Nature Conservation Council

Additional Submission of Objection

Integra Mine Complex Modification 4 - Biodiversity Offset Strategy
08_0101 MOD 4 and 08_0102 MOD 4

Figure 5: Existing Biodiversity Offset Areas

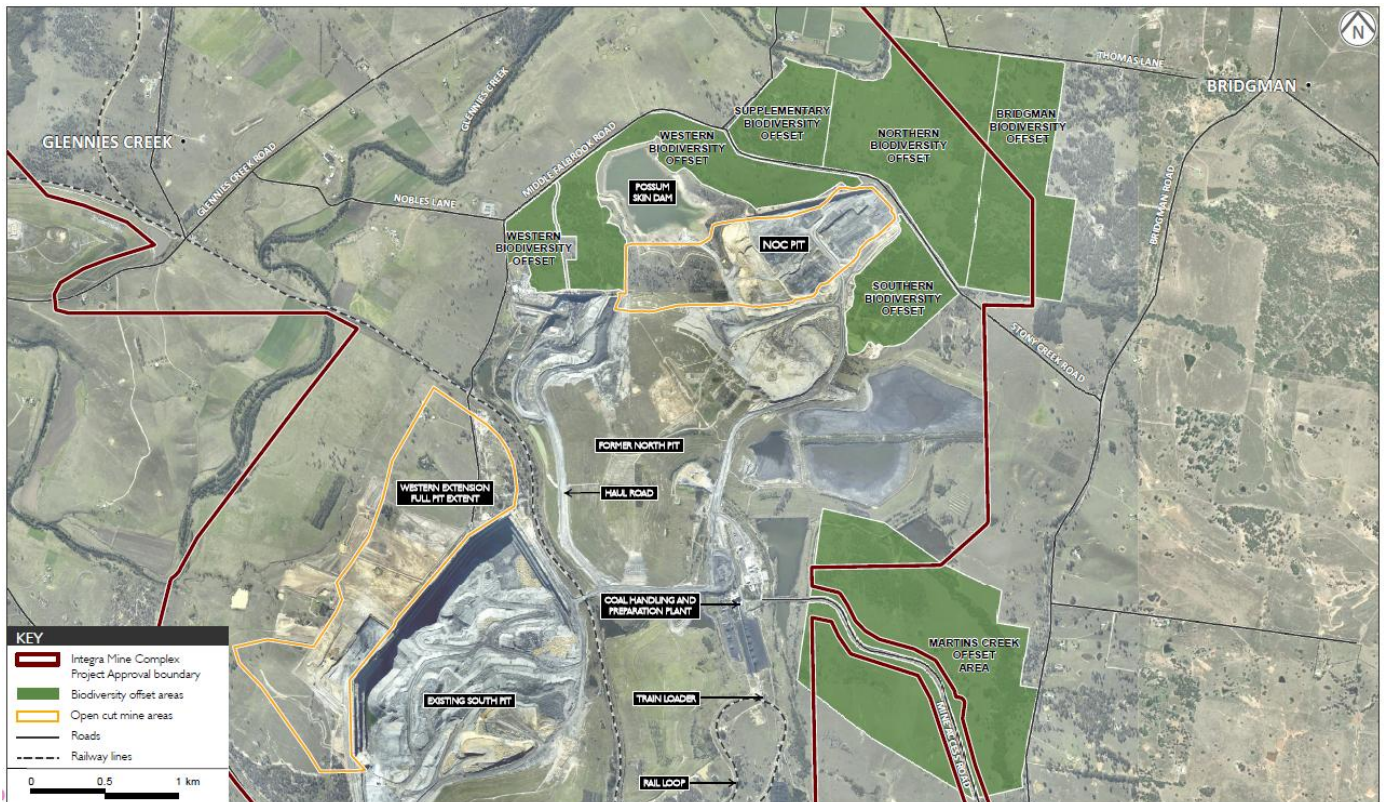
1. The proposal to remove the Supplementary and a significant section of the Northern onsite BOAs will impact on the protection of a large meander in Glennies Creek.

The Supplementary and Northern BOAs assist in protecting an edge of the alluvial aquifer system of Glennies Creek, as demonstrated in Appendix 7 of the conditions of consent. These additional biodiversity values are not identified in the assessment report.

2. The loss of the Western onsite BOA and a significant section of the Martins Creek BOA reduces the connectivity design of the current approved Biodiversity Offset Strategy.

The loss of connectivity to Glennies Creek and the loss of the corridor to the west are significant.

The breakup of the Martins Creek BOA also removes connectivity at the northern end of this area. The justification for this excision is for a proposed dam. However, the assessment report does not provide any information on this proposed change to the current approval.
